**KIRKLEES METROPOLITAN COUNCIL
INVESTMENT & REGENERATION SERVICE**

DELEGATED DECISION TO DETERMINE PLANNING APPLICATIONS

Reference No:	2022/62/92099/W
Site Address:	72, Meltham Road, Honley, Holmfirth, HD9 6HL
Description:	Erection of two storey side and rear and single storey rear extensions
Recommending Officer:	Tom Hunt

DECISION – REFUSED

3. Proposed Site Layout

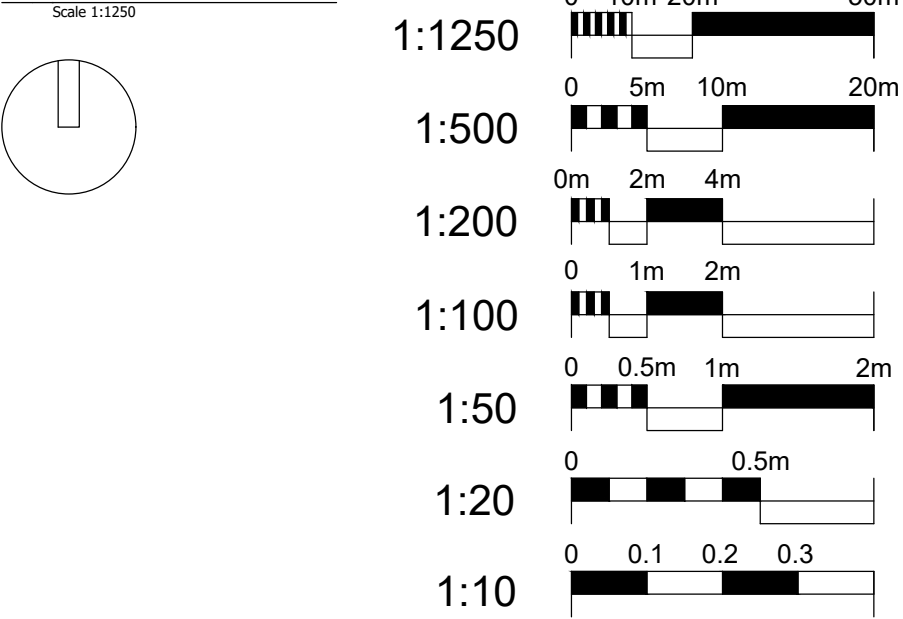
For a 4 plus bedroom dwelling, it is advised that it should have three off street parking spaces. The proposal would have the removal of a parking space to the side of the property with a retained, limiting the amount of off street parking to the fore. The paired semi-detached neighbour has an integral garage within its side extension which aided it in providing some mitigation to their loss of parking at the time.

Officers discussed parking impacts with the applicant's agent and request submitted parking layout plans which were provided set out off street parking provision despite this loss. The revised plan now shows a section of

landscaped area to the front remaining providing off street parking for two cars. The Officer is dubious that this could be achieved safely within the limited widened access however parking on site for two cars could be dealt with by condition to set out parking to be approved by the LPA to progress the application should it be approved at a future date, with an adequate amount of landscaping to the front being retained to prevent the frontage being dominating hard-standing.

1. Proposed Ground Floor Plan  
Scale 1:100

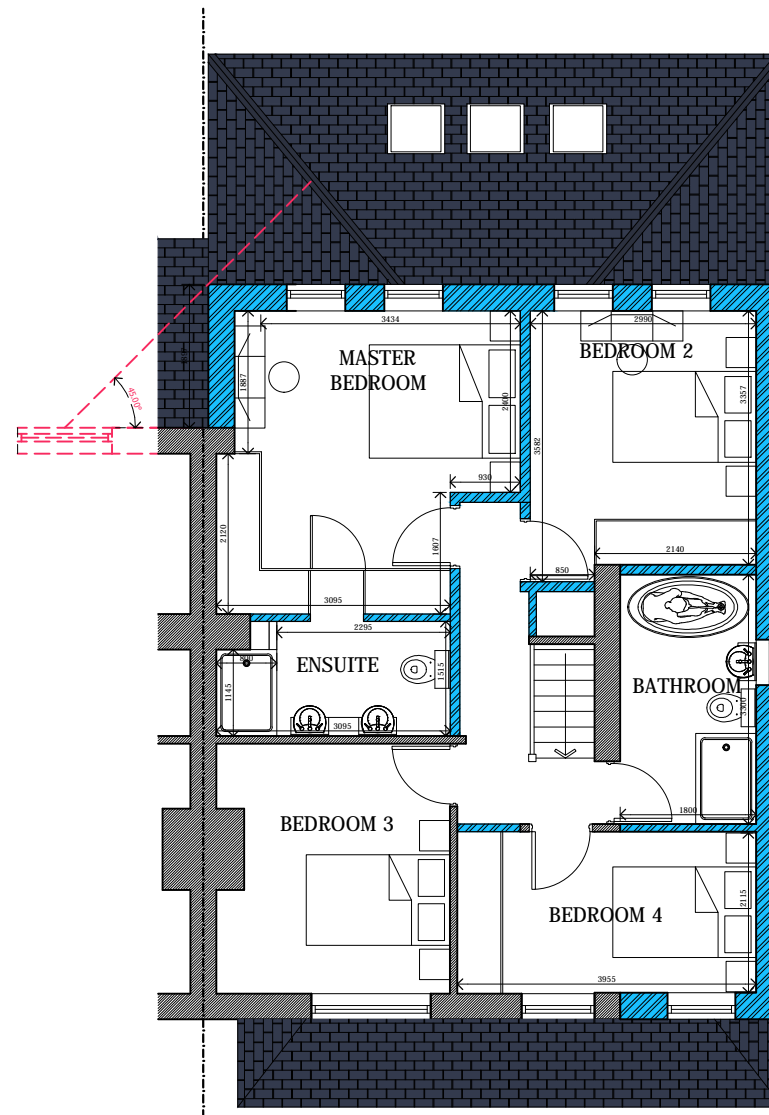
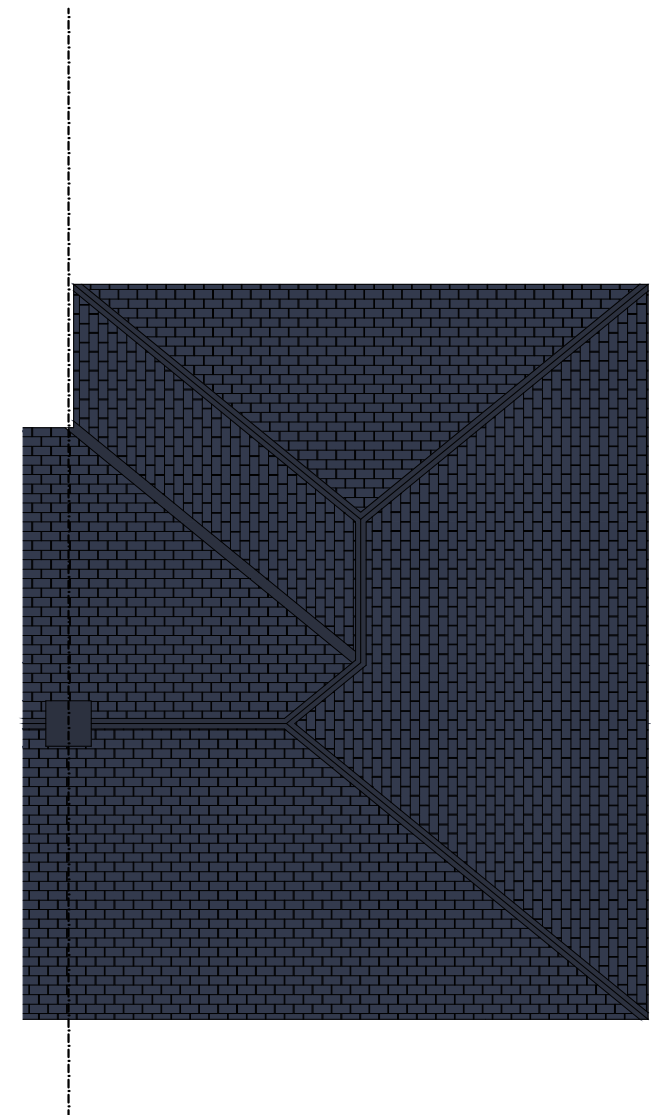
The proposed design of the two storey extension element would be full span of the host, and extended to cover the rear wall of the side extension too. This aspect in combination with the single storey rear extension which covers a similar width, would cumulatively project beyond the recommended depth for rear extensions advised in the SPD. It would also result in the rear extensions dominating and obscuring the existing rear wall of the property. Whilst, it is acknowledged that the next door neighbouring property has extended to the rear, the two storey element is not as large next door, being set off from the side boundary, and there is no single storey protrusion beyond this. The overall extension would protrude ~2.4 beyond the extension at No.76. The proposed rear extensions together are considered to be materially larger than what has been developed next door. In addition to this, these extensions were approved prior to the House Extensions and Alterations SPD, the NPPF, the Kirklees Local Plan and the National Design Guide, all of which stress the importance of good design.

The hipped roof design of the single storey element would be contrast to the next door neighbouring extension with a simple lean-to form, that would protrude further forward of this adding to an inharmonious and complicated design.

The large rear extensions, in combination with the relatively large two storey extension, would increase the amount of development to the original dwelling, and the proposal would dominate this original dwelling, which is considered to be contrary to Principles 1 and 2 of the House Extensions and Alterations SPD.

Considering Principle 2 of the House Extensions and Alterations SPD and Policy 2 of the HVNDP, the cumulative extensions would have dominant additions made to the host, obscuring the side elevation and the rear completely with only the primary elevation left relatively exposed. It would be out of scale with its paired neighbour, protruding beyond their own extensions to have an unsympathetic, dominant and oppressive design to the original house and its paired neighbour.

Thus, it is considered that the proposed extensions together, given the overall massing and scale, form and design, would fail to represent a subservient addition to the host property or be in keeping with the host building. The proposal would introduce an unsympathetic, incongruous, complicated and dominant form of development. The proposal is therefore contrary to Policy LP24 (a and c) of the Kirklees Local Plan, Principles 1 and 2 of the House Extensions and Alterations SPD, Policy 2 of the HVNDP and Government guidance contained within Chapter 12 of the NPPF.

1. Proposed South Elevation
Scale 1:100

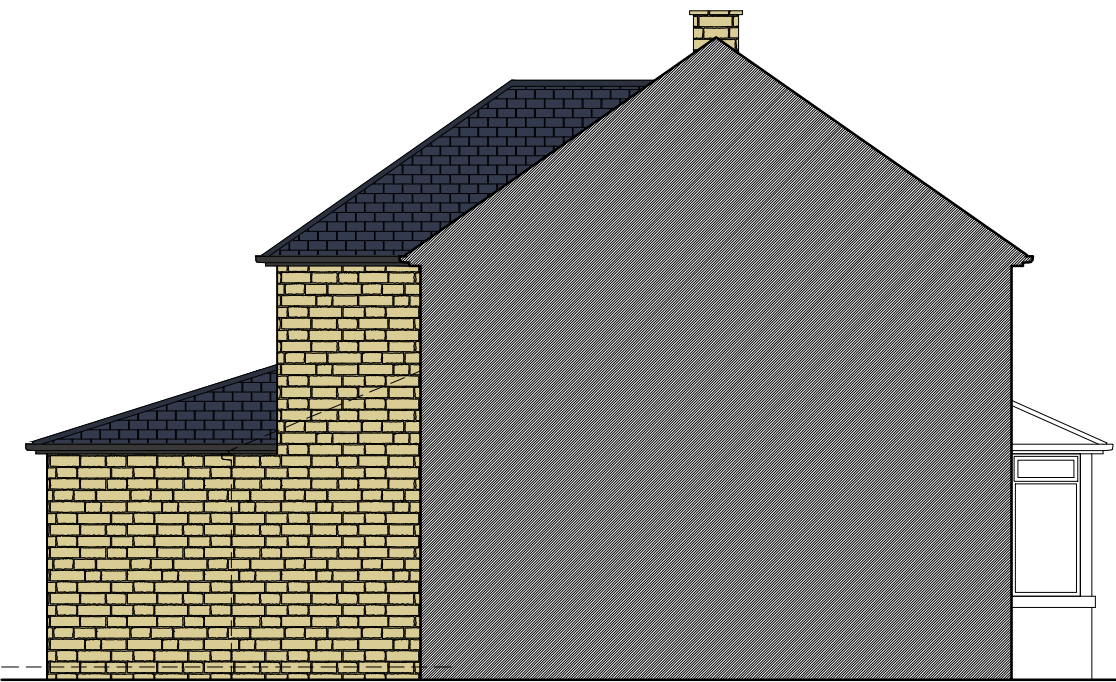
The proposed side extension element would not conform to the SPD guidance of being visually smaller than the host nor set back 0.5m from the front wall to have a design that is clearly subservient. This is due to a similar front wall line and eaves and ridge height. That said, it is noted that it would still have a property boundary gap near to 1m. Whilst this is considered unfortunate, this extension in isolation could potentially be acceptable given that the attached neighbour had extended similarly to the side, and this would prevent an unbalanced design. In addition, the property gap and the elevated position of No. 72 would aid the design in avoiding undue terracing which has occurred between No's. 52 and 50 of the same road.
